**Consultation Response from KC,
Lead Local Flood Authority**

2022/91735 Land off, Hermitage Park, Lepton, Huddersfield, HD8 0JU

Outline application, with access and layout, for the erection of 80 dwellings and associated work

**Date Responded: 16th March 2023
Responding Officer: Paul Farndale
Responding Ref:**

Drawing Title.
EXISTING DRAINAGE

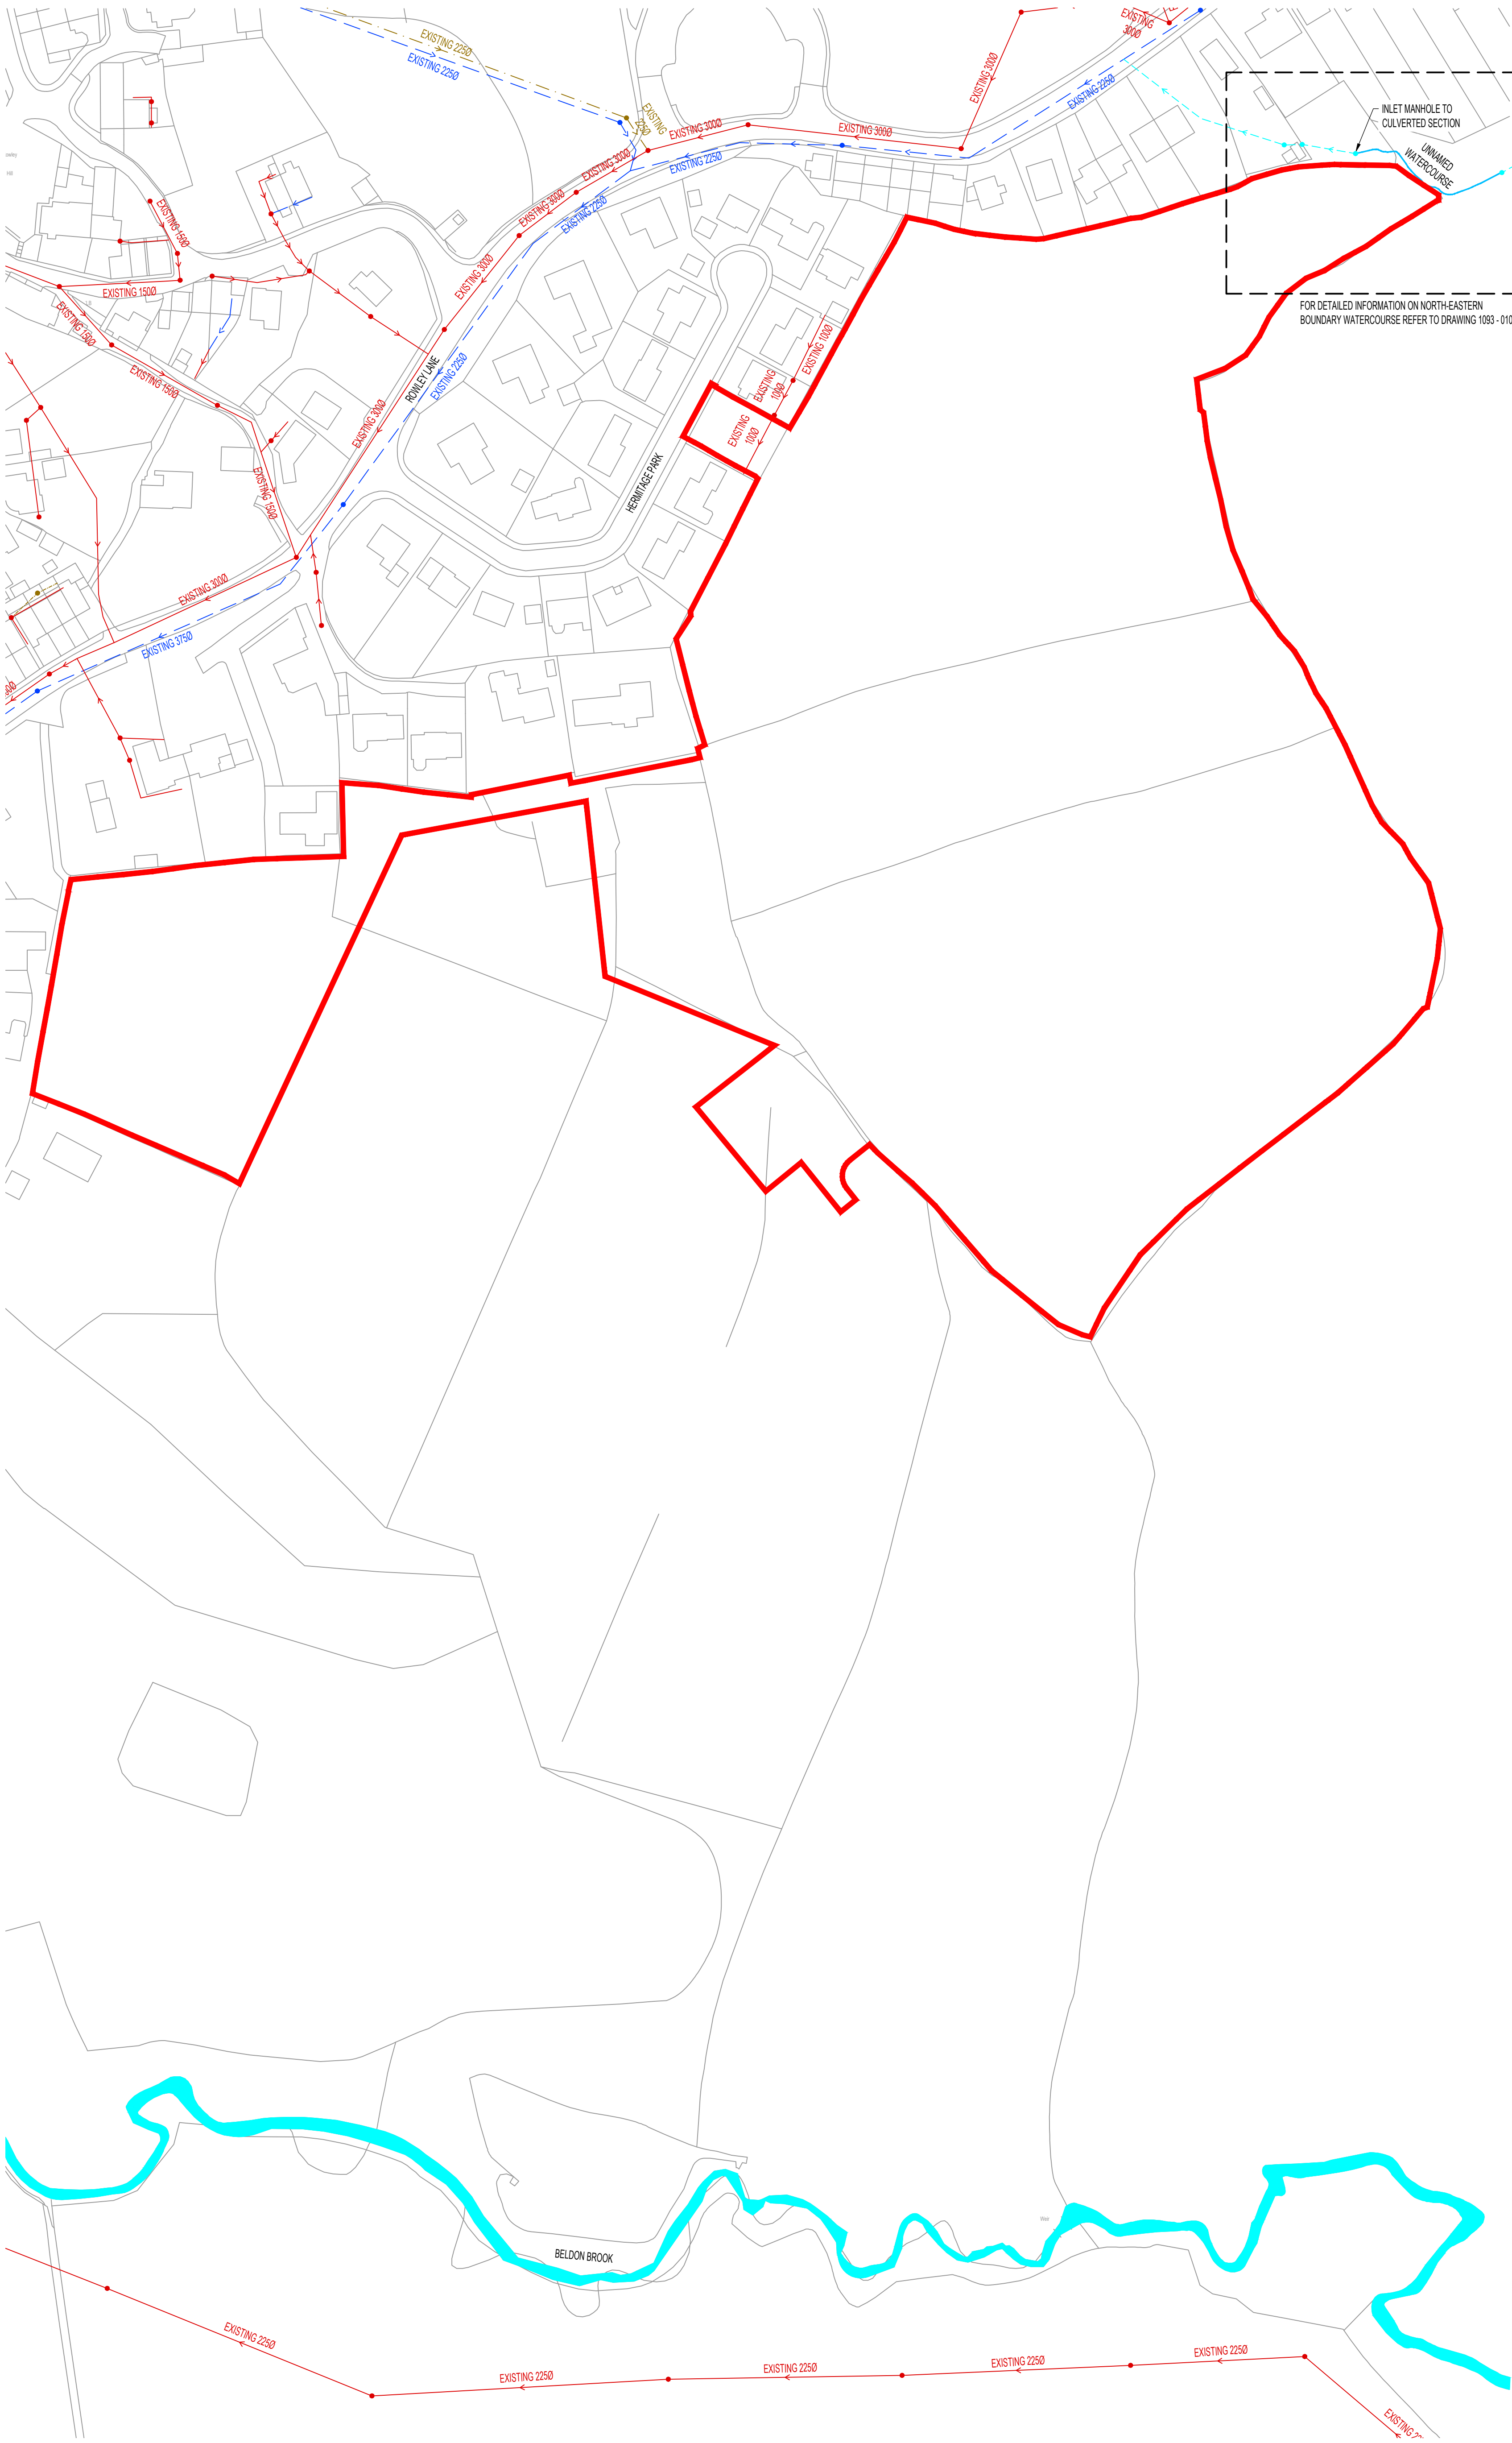
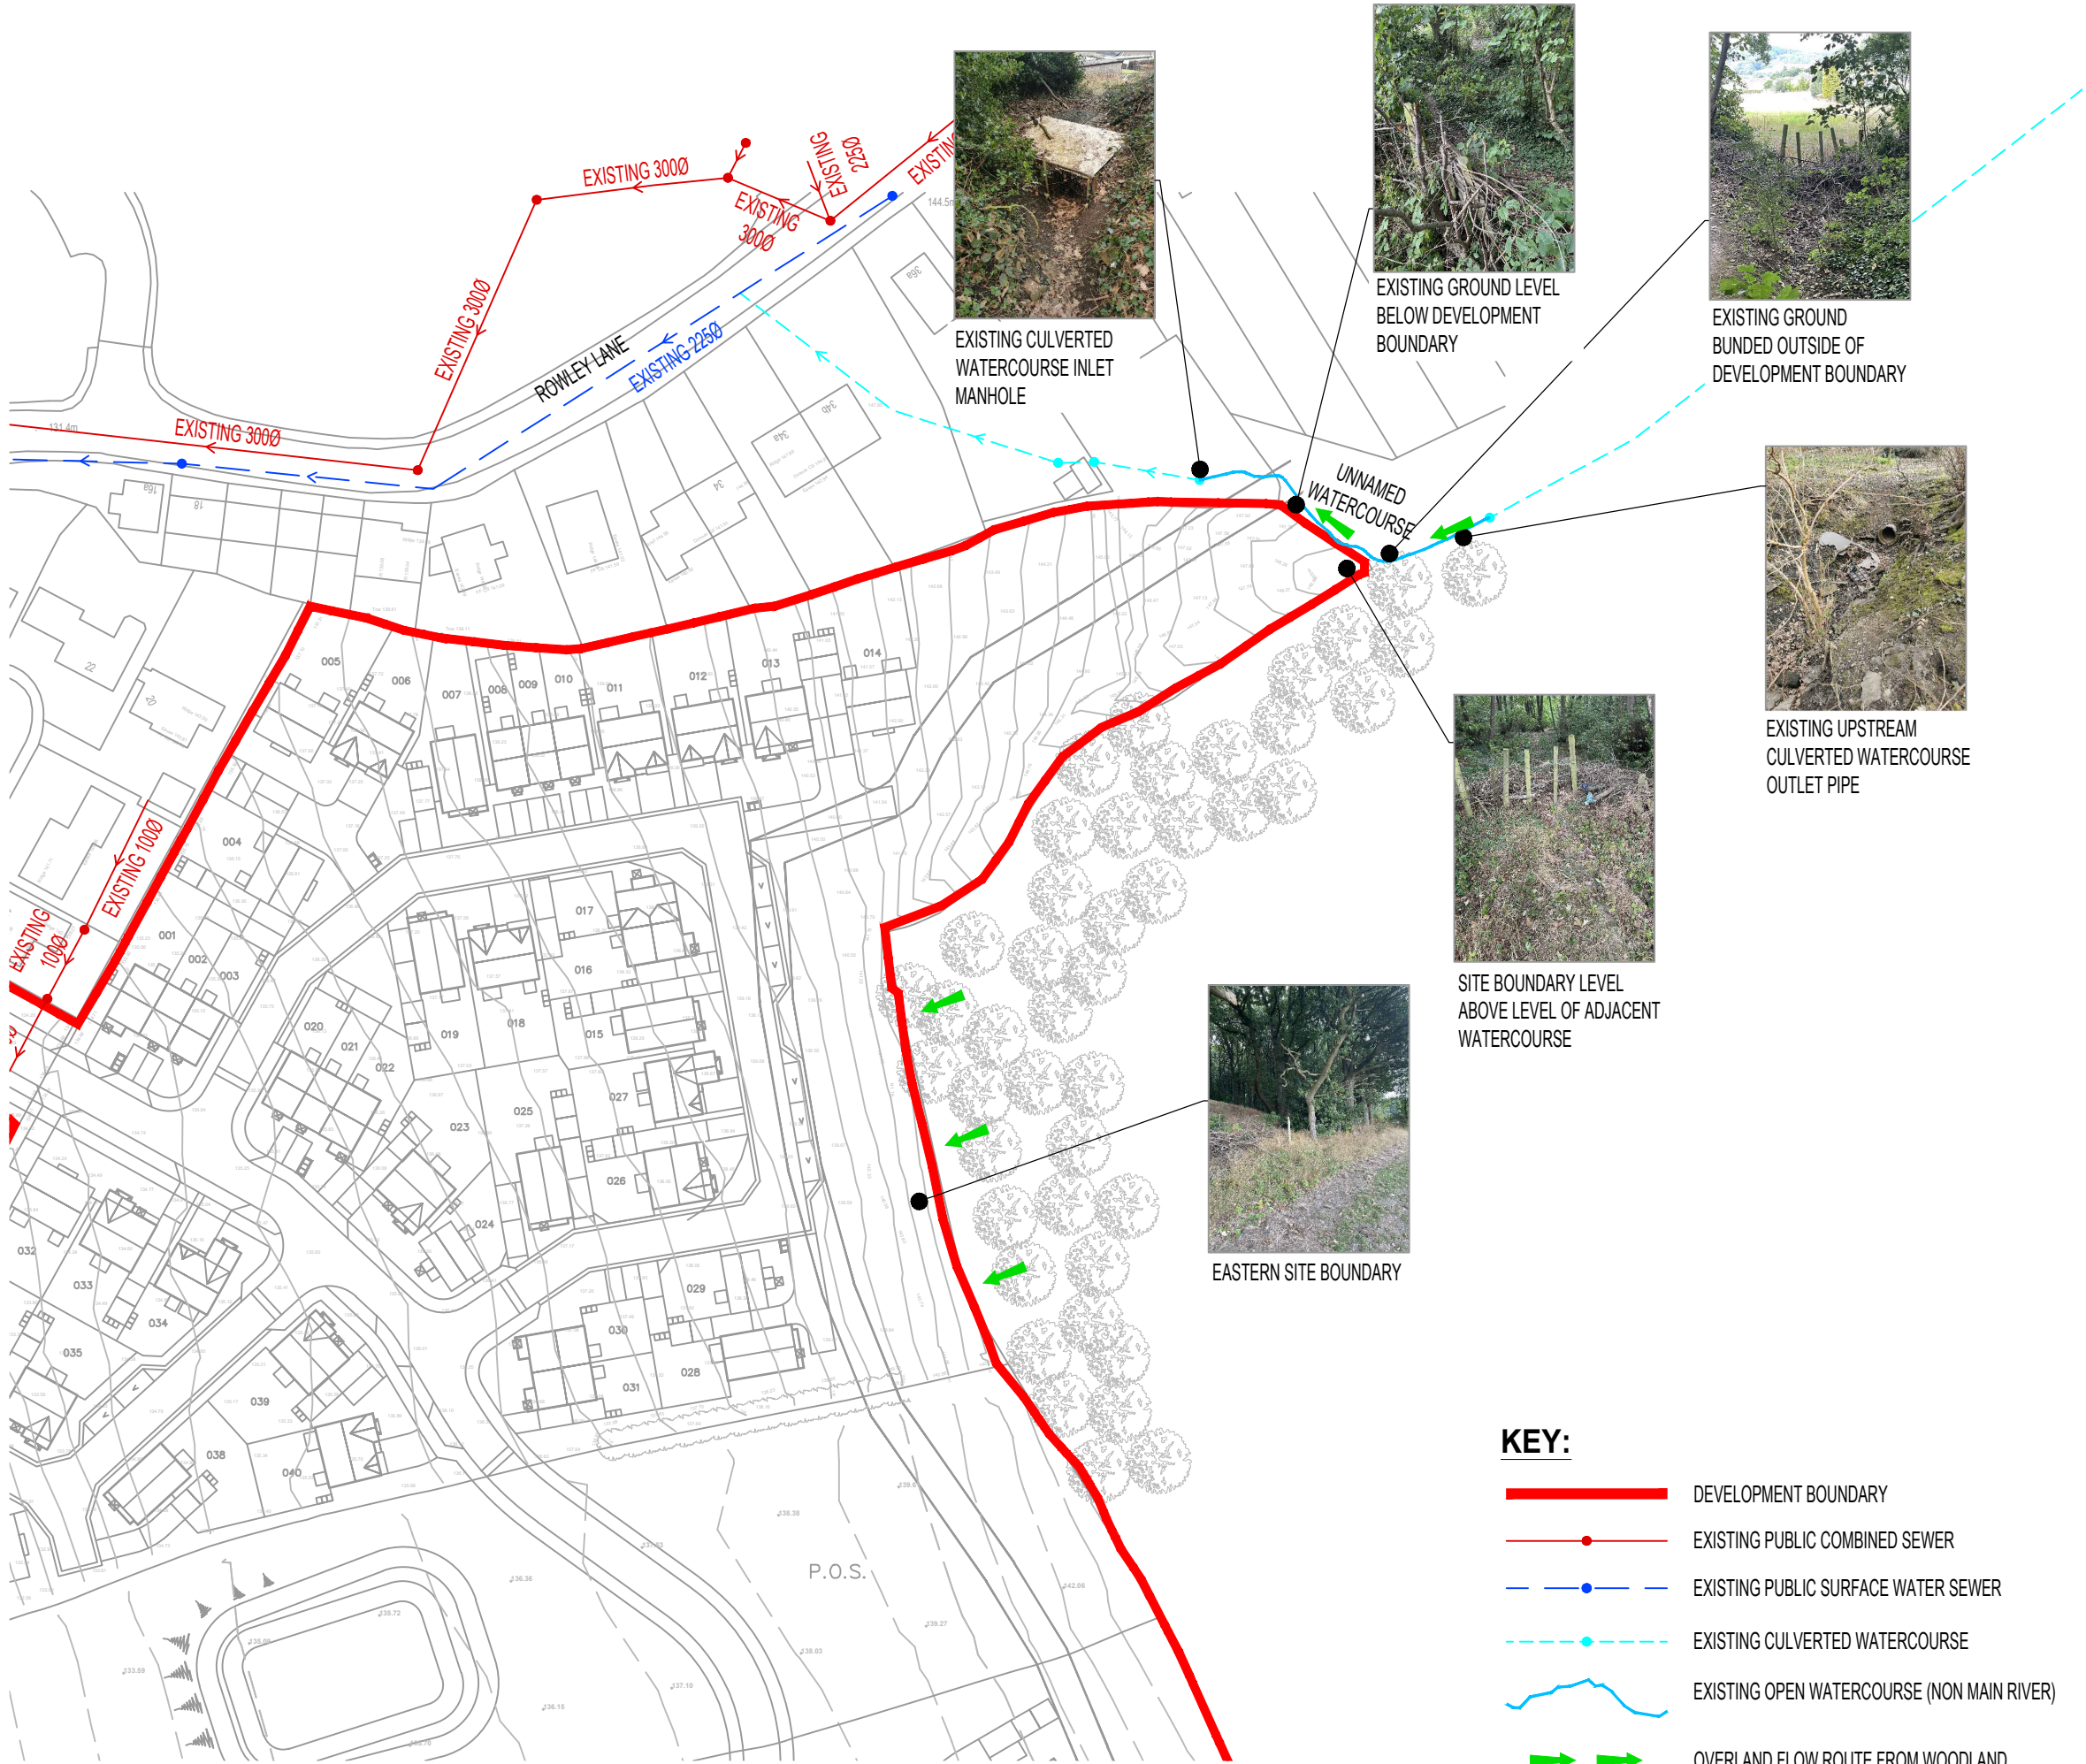
Levels have been submitted showing blockage route of the north-eastern watercourse. As a belt and braces approach a cut off swales has been included on all drawings as the watercourse has been illegally diverted through the site previous. Risk mitigation is accepted.

The watercourse still needs to be surveyed as part of the risk assessment but can be conditioned. This also applied to the examination of an improved trash screen. It is expected that the applicant will liaise with the LLFA over this matter.
